From: Laura Gibbons
Sent: 08 April 2019 12:08
To: Anita Gardner
Cc: Planning.Responses
Subject: RE: FG/29/19 South Point, Beehive Lane, Ferring

Project			
Land at South Point Beehive Lane Ferring			
Client			
Globe Estates (Southern) Ltd			
Drawing Title			
Surface Water Drainage			
© This drawing is copyright It may not be copied or reproduced without written authority			
Scale	As shown	At original	A3
Drawing Number	2019/SK2		Revision
			-

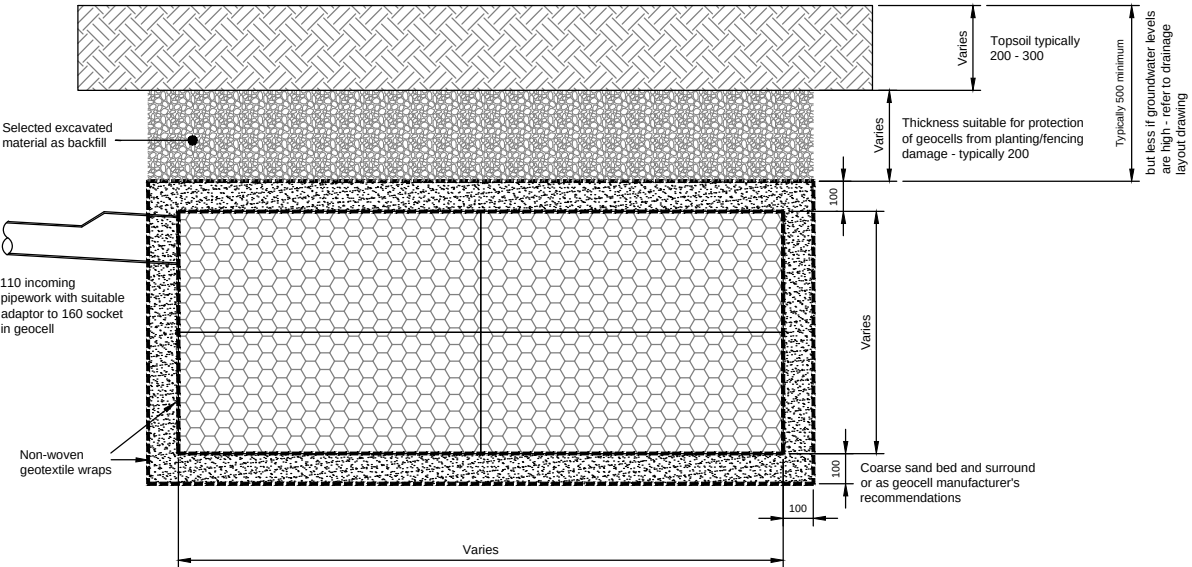
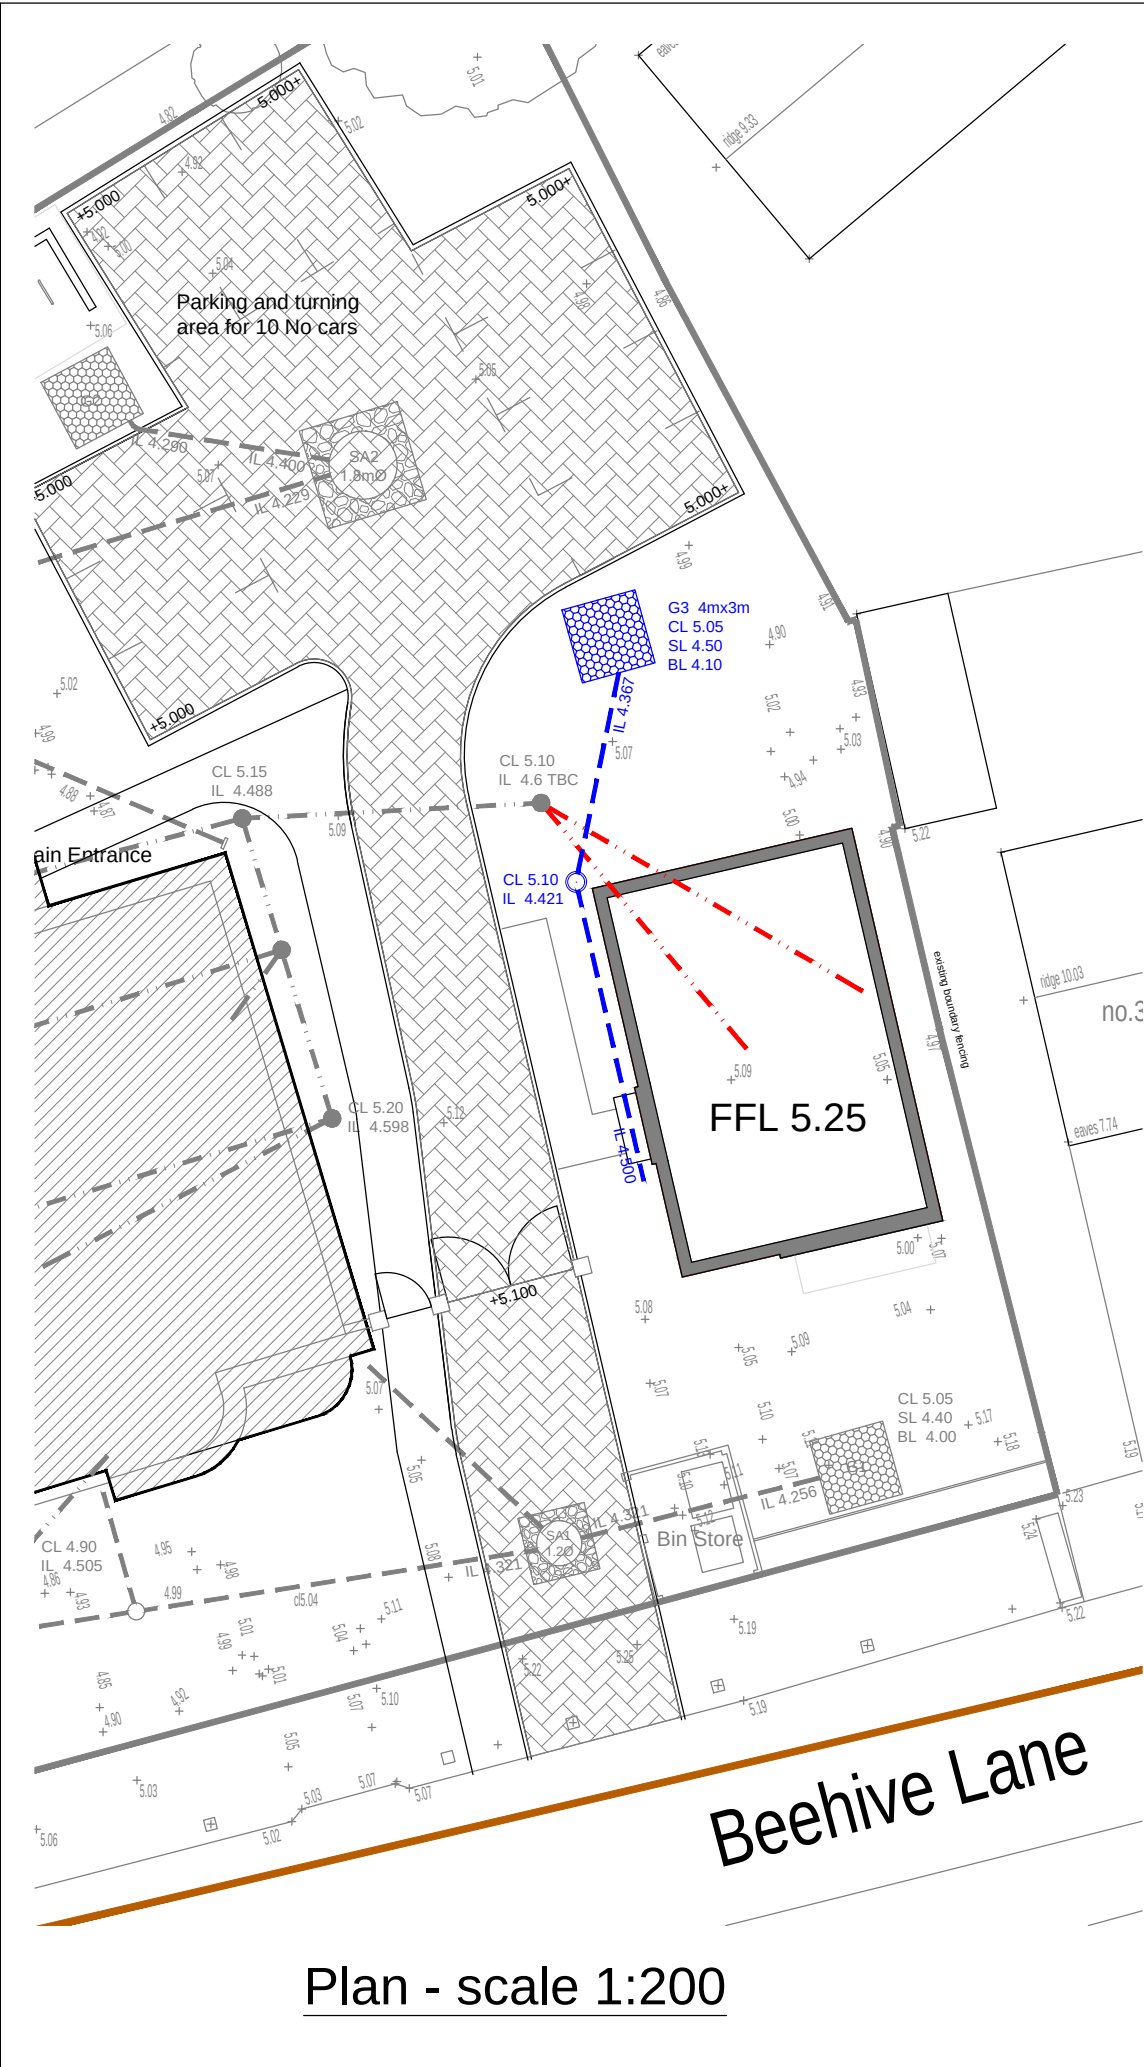
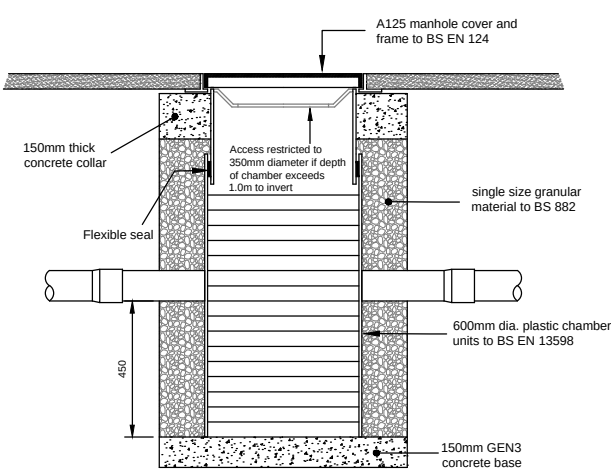
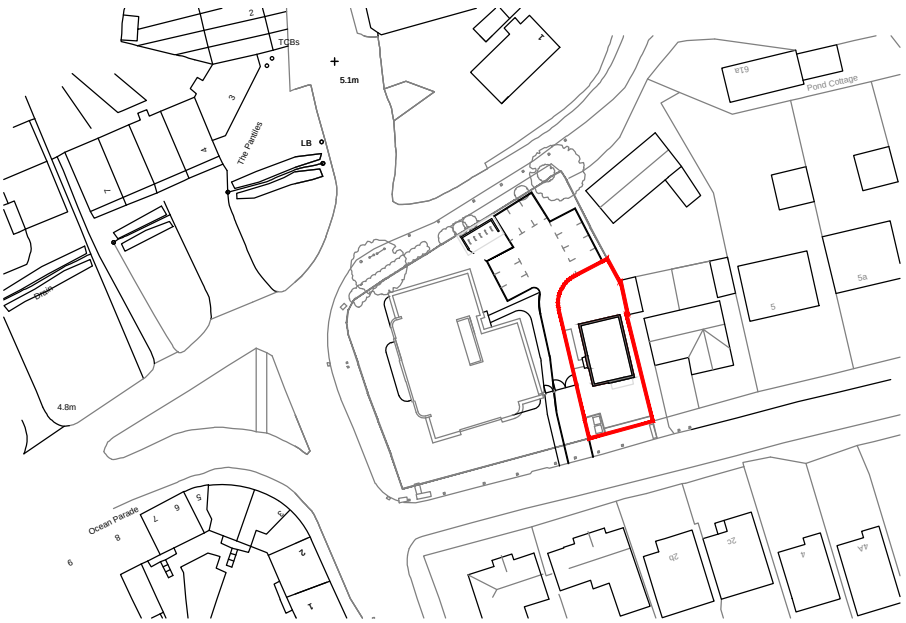
Please can it be confirmed by the applicants engineer what the duration of groundwater monitoring was? Furthermore, the base of the soakaway is proposed to be located at 1.05m depth yet groundwater was encountered at 0.954m depth. The base of the soakaway must be located above maximum winter groundwater level.

I am happy with the supplied details (attached) and therefore do not require a pre-commencement condition to be imposed. If we can please instead ensure that drainage is conditioned so that it is built in accordance with the supplied details.
